From: Juan Baeza
Sent: 18 January 2018 08:51
To: Planning.Responses
Cc: Amanda Scholes
Subject: WA/78/17/DOC

From: Paul Cann
Sent: 17 January 2018 16:14
To: 'Brendan Haworth'
Cc: Andrew Davey; Mark Willis; Des McCall; Jack Dexter; Juan Baeza
Subject: RE: Walberton

Subject: Walberton

Project: Red Cottage, West Sussex
Drawing No.: 536/501
Drawing Title: Typical Soakaway Section A-A
By: JD
Date: November 17

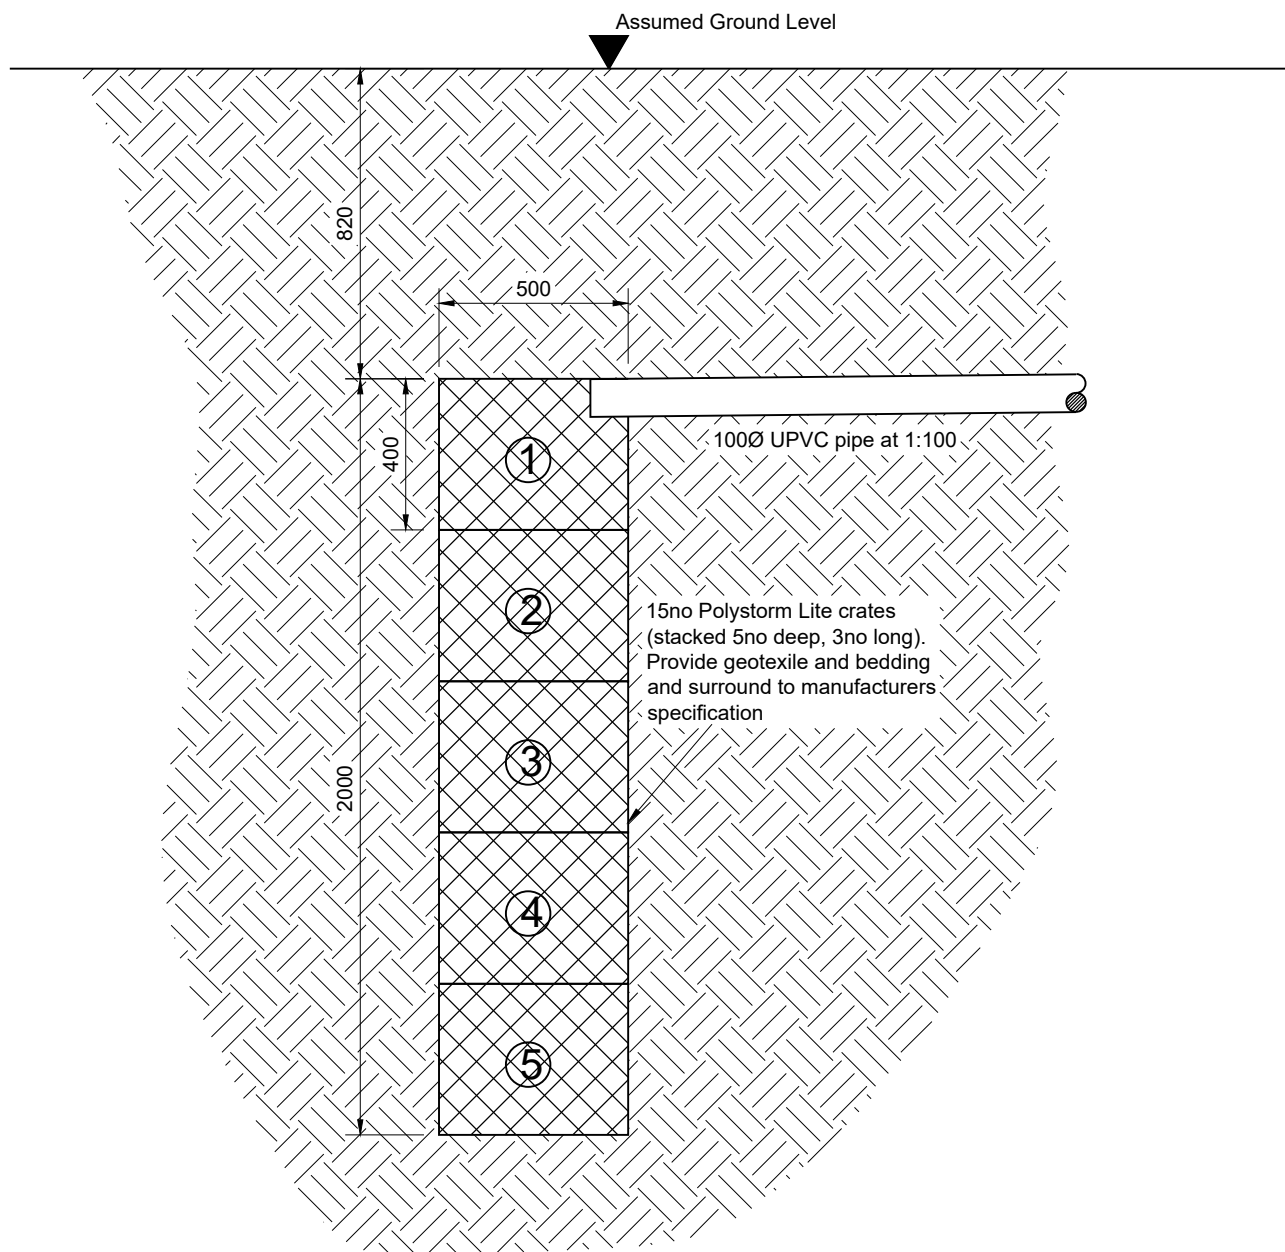
1. Please provide all the readings associated with the 13 minute percolation test ie. water level readings from 0 mins to 13mins, so the rate can be checked.
2. The storage calcs show a minimum soakaway depth of 1.944m being required. How can this be achieved based upon the design requirements. ie. soakaway base must not extend more than 2m below ground level and you also need to achieve adequate cover to the crates for protection.
3. Please show manhole cover/invert levels, including pipe invert at connection to soakaway.
4. Specify base level of soakaway ie. a level max. 2m below ground level.
5. Provide construction detail/section of soakaway (to include permeable geotextile wrapping).
6. Manhole SW4 is to be a catchpit (provide construction detail).
7. How is the driveway being drained? Provide full details/calculations.

I look forward to receiving your design drawings (layout and construction details). Please note that the depth from ground level to the base of the soakaway must not exceed the depth of your trial hole.
